From: Glenn Gasson <[REDACTED]>
Sent: 10 January 2022 14:32
To: Simon Davis
Cc: Shane Noone; Neil Drinkwater
Subject: RE: Planning Consultation on: A/255/21/DOC
Attachments: C1249_100_AB_Drainage Layout.pdf; Hydrobreak Invoice.pdf; Polystorm Invoice.pdf; 1727_SuDS Verification Statement_P1.pdf; Photo 1.jpg; Photo 2.jpg; Photo 3.jpg; Photo 4.jpg; Photo 5.jpg

Engineers Comments Regarding Condition 5

<p>cgs civils Consulting Civil Engineers</p>					
CLIENT		GD GROUP			
ARCHITECT		CITYZEN			
JOB TITLE		MERRY ENGLAND ANGMERING			
DRAWING TITLE		DRAINAGE LAYOUT			
DRAWN	LH	ENGINEER	CS	CHECKED	CS
DATE	SEPT 2019		1:200		
DRAWING No.	C1249	STATUS	C	DRAWING No.	100
REV	A

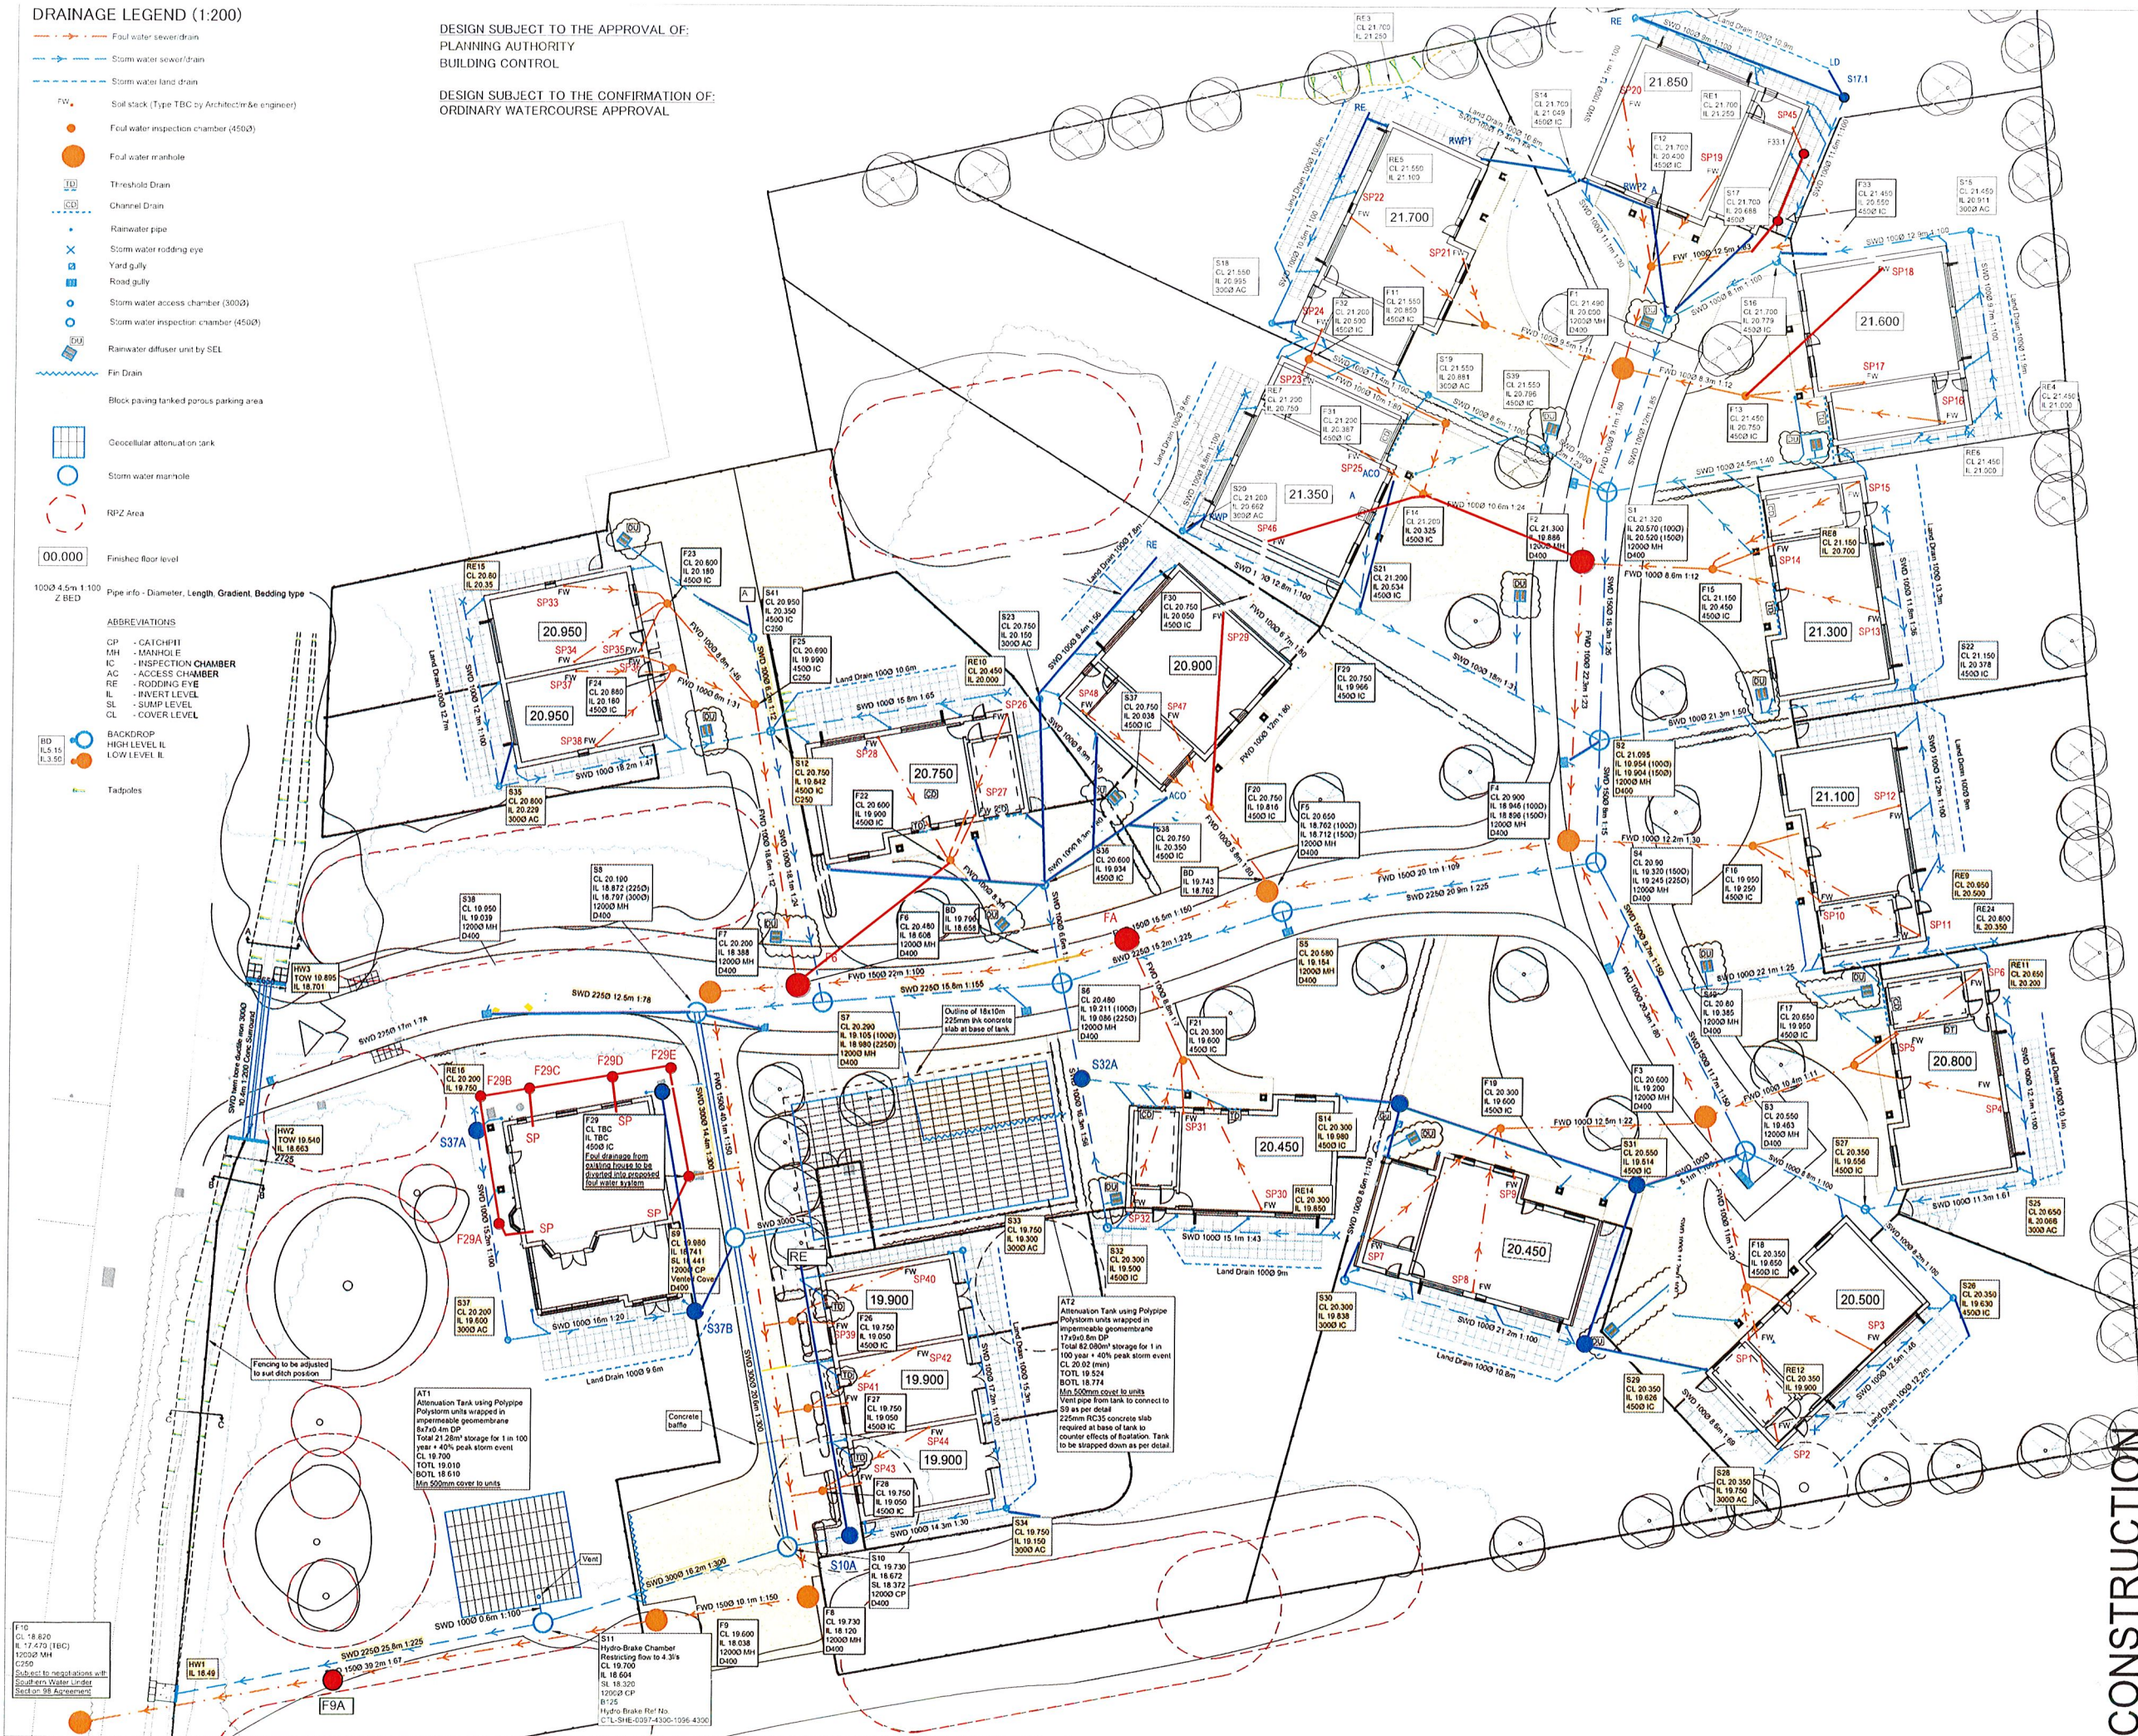
1. The as built drawings supplied are inaccurate. The extents of channel and threshold drains are not accurately depicted. Inspection chambers are also not consistent with what has been constructed on site. A full review of features constructed on site and drawings must be completed by the applicant. -- As Build Drainage Layout attached
